**TOWER 2, LEVEL 23
DARLING PARK, 201 SUSSEX ST
SYDNEY NSW 2000**

RESPONSE TO SUBMISSIONS (BUILT HERITAGE) SUPPLEMENTARY LETTER - LINDFIELD LEARNING VILLAGE

The purpose of this letter is to provide comment from a heritage perspective on the proposed construction staging within the previously proposed development. This application seeks partial development consent for the school.

- LEGEND:
- PHASE 1
 - PHASE 1: ADMINISTRATIVE
 - 100M APZ
 - 2HR FIRE RATED WALL
 - PHASE 1: PLANT ROOM

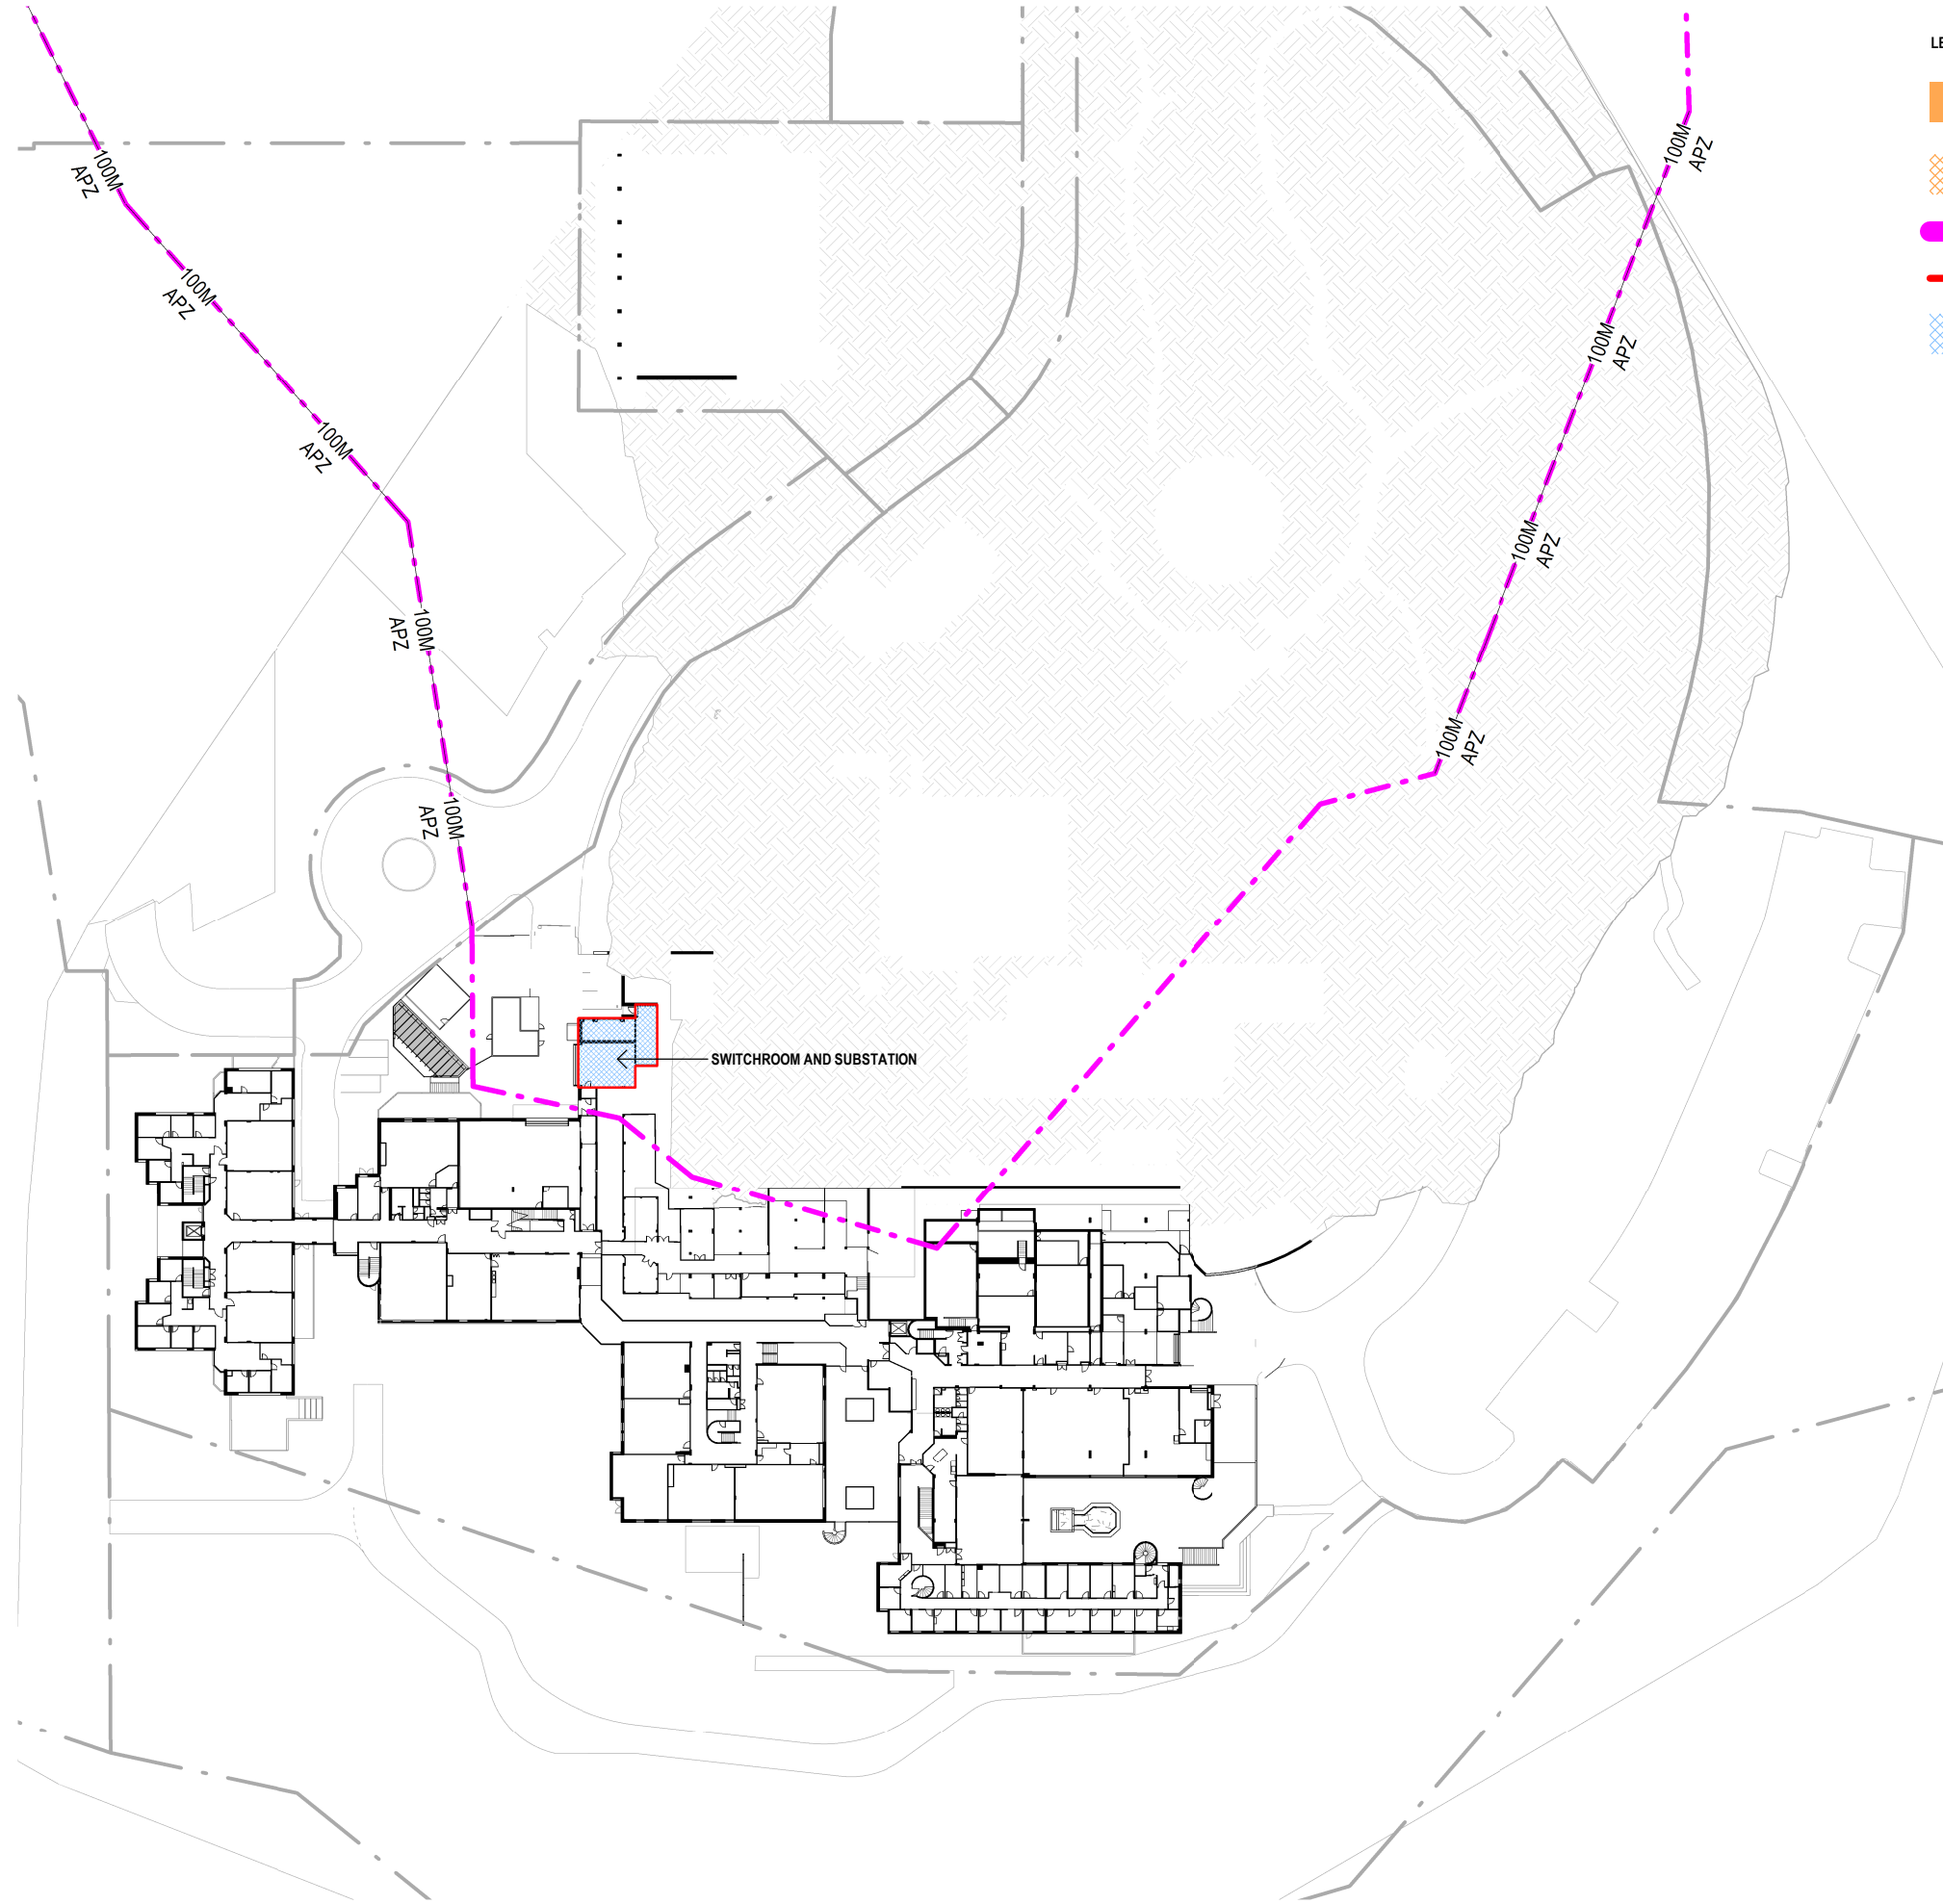
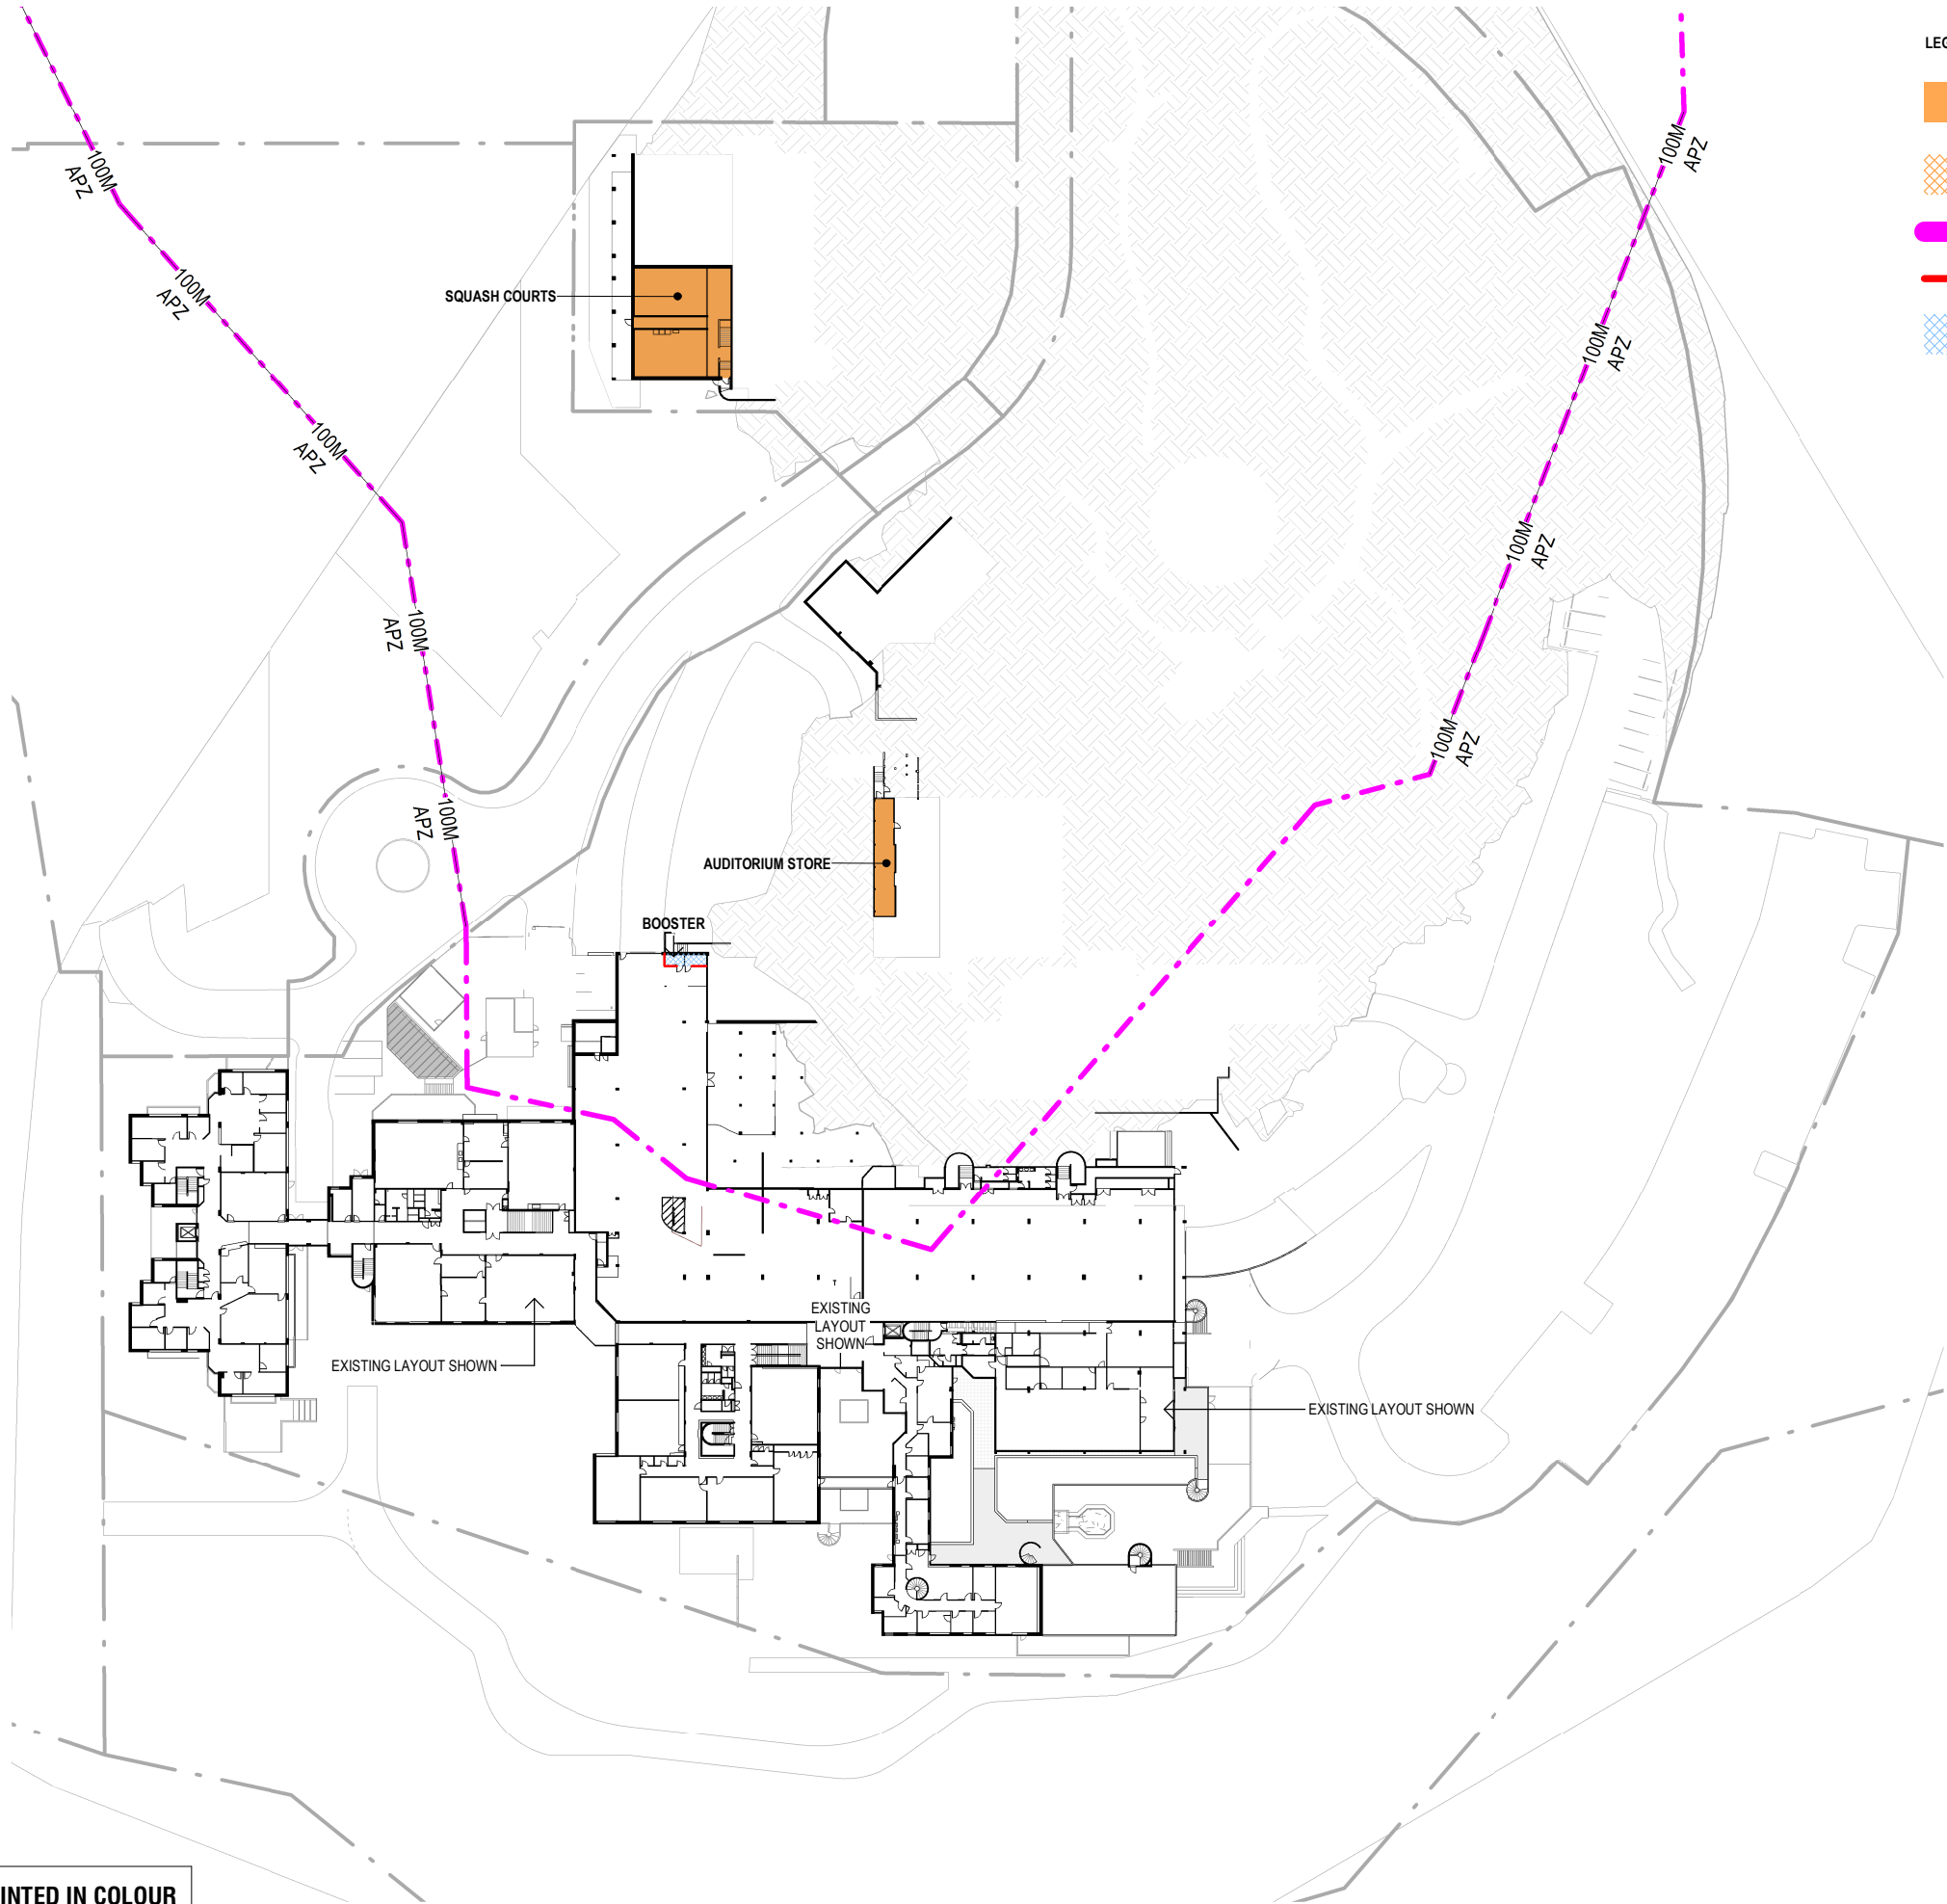
There is a fire wall proposed on the alignment of the fire protection zone.

The fire wall would intersect key spaces including the cafeteria and may present as an ad hoc addition. It is however recognised as a necessary measure to ensure the school is able to function in a limited capacity by 2019 and is therefore an acceptable impact.

It is recommended that a methodology be prepared for the construction of the wall which ensures that it is reversible. This would ensure that the southern portion of the school can be seamlessly incorporated into the Phase 1 school pending an appropriate bushfire resolution. It also ensures that there would be no permanent impact on the building should the remainder of the school not be reused, and the Phase 1 school vacates the site in the future.

- Complete tree removal is proposed under this application as a 'worst case scenario'. To mitigate some of the negative heritage impact of denuding the site of all trees Urbis strongly recommends that the number of trees for removal be considered carefully and minimised as much as possible.
- A methodology should be prepared for the installation of the fire wall in conjunction with the heritage consultant such that it is entirely reversible.
